**KIRKLEES METROPOLITAN COUNCIL
INVESTMENT & REGENERATION SERVICE**

DELEGATED DECISION TO DETERMINE PLANNING APPLICATIONS

Reference No:	2026/62/90417/E
Site Address:	8A, Grove Terrace, Birkenshaw, BD11 2LY
Description:	Erection of detached outbuilding to create dwelling forming annex accommodation associated with 8A, Grove Terrace, Birkenshaw, BD11 2LY
Recommending Officer:	Jennifer Booth

DECISION - REFUSED

FLOOR PLAN
1:50

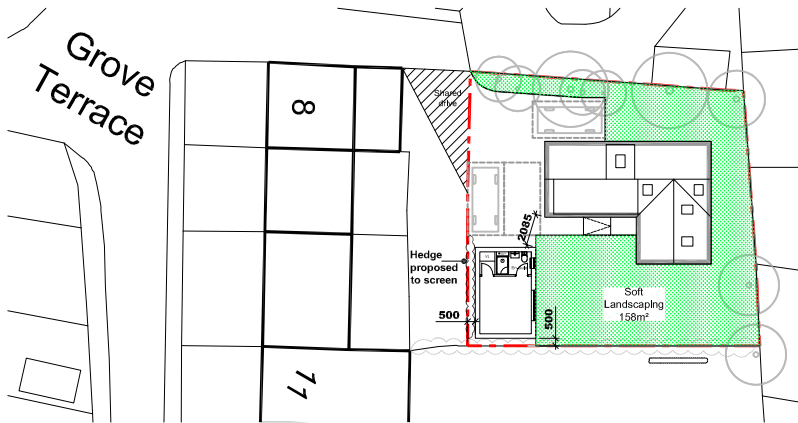
The applicant has referenced the NDSS requirements for bedroom sizes, which specify that a single bedroom providing one bedspace should measure at least 7.5sqm with a minimum width of 2.15m, and a double bedroom at least 11.5sqm. The proposed bedroom, at approximately 12sqm, would meet the minimum requirement for a two-person bedroom in isolation.

However, when assessed holistically, the annex would provide a total floorspace of approximately 16sqm. Whilst the bedroom itself meets minimum size guidance, the overall quantum of space remains limited and would not comfortably support associated functions, circulation, storage, and any ancillary facilities within the structure. As such, the accommodation would appear constrained.

Having considered the above factors, the proposals are considered to result in an unacceptable impact upon the residential amenity of the future occupant of the annex. The limited internal floorspace, poor layout, and constrained living conditions would fail to provide a reasonable standard of accommodation, resulting in a cramped and substandard living environment.

The proposed annex, by reason of its limited overall floorspace (approximately 16sqm) and constrained internal layout, including a bedroom of around 12sqm, would fail to provide an adequate standard of accommodation for its intended occupant. The development would result in a cramped and substandard living environment, falling significantly below the Nationally Described Space Standards and failing to ensure acceptable living conditions. The proposal is therefore contrary to Policy LP24 (criterion b) of the Kirklees Local Plan, Key Design Principles KDP3, KDP5, KDP6 and KDP7 of the House Extensions and Alterations Supplementary Planning Document, and the aims of Chapter 12 of the National Planning Policy Framework. The NPPF has introduced a presumption in favour of sustainable development. The policies set out in the NPPF taken as a whole constitute the Government's view of what sustainable development means in practice.

PROPOSED SITE PLAN
1:500

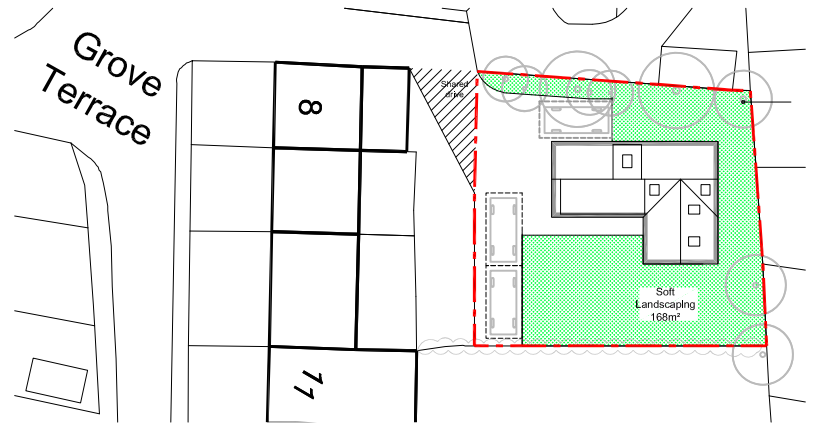
The outbuilding measures 6 x 4 metres and is of a permanent stone construction. It is shown tucked into the corner to the front of the dwelling within existing amenity space thereby reducing the amount of useable space associated with the dwelling. The original parking area is reorganised to provide spaces side by side which appear cramped.

The revised parking shows the displaced parking spaces tucked side by side adjacent to the dwelling. Due to the limited space afforded to the two spaces manoeuvring and accessing vehicles would be severely restricted to the detriment of pedestrian and highway safety.

Due to the scale and location of the development proposed, parking for two vehicles would be displaced. The proposed layout for off street parking would be constrained within the plot adding further weight to the overdevelopment of the site as well as concerns regarding accessibility and highway safety contrary to Policies LP21 and LP22 of the Kirklees Local Plan along with Key Design Principles 15 & 16 of the House Extensions & Alterations SPD.

2. The two replacement parking spaces shown are substandard in terms of width and layout and would be difficult to manoeuvre and access to the detriment of pedestrian and highway safety contrary to Policies LP21 and LP22 of the Kirklees Local Plan and Chapter 9 of the National Planning Policy Framework.

B	Hedge shown	Feb 26
A	Footprint & height of Garden Room reduced	Feb 26
REV	DESCRIPTION	DATE
APPLICANT		
MR JUDGE		
PROJECT		
8A GROVE TERRACE, BIRKENSHAW, BD11 2LY		
TITLE		
DETACHED GARDEN ROOM PROPOSAL		
Date	Scale@A3	DWG No.
NOV 2025	AS NOTED	A-20-10
REV	DATE	
B

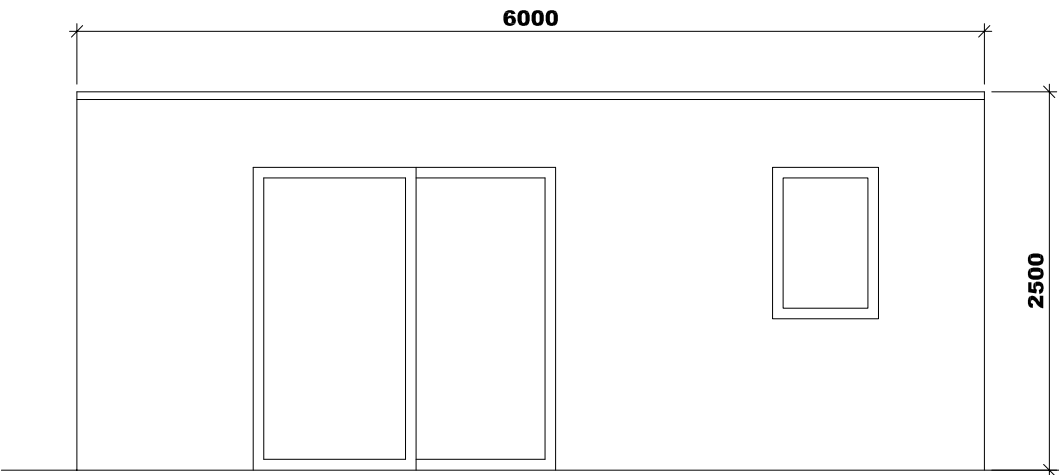
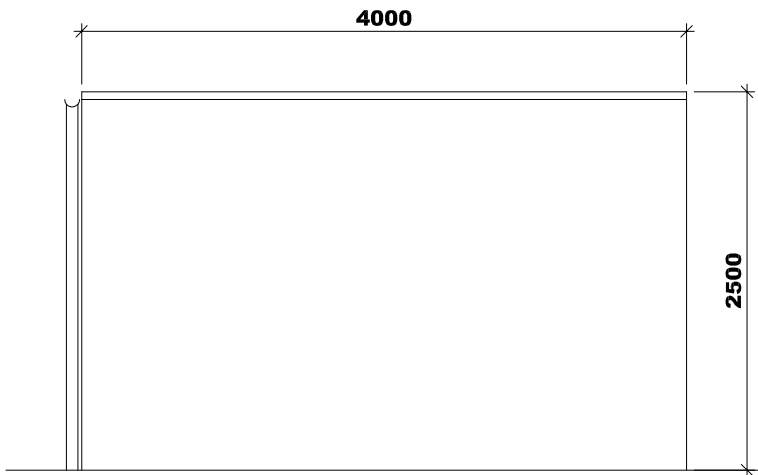
The erection of an annex would result in further development within an already constrained site, which would appear visually intrusive and out of keeping with the established character of the area. Anything beyond a small domestic shed would be considered excessive and likely to have an unacceptable impact on visual amenity.

Having taken the above into account, the proposals are considered to detract from the character of the area and balance of development to green space detrimental to the visual amenity of both the host dwelling and the wider street scene. The scale, form and layout of the development along with the reorganisation of parking would appear harmful in the context of the modest plot. The scale is such that it would not represent a sympathetic or subservient addition to the host property. Instead, the development would appear visually intrusive and out of keeping with the established character of the area.
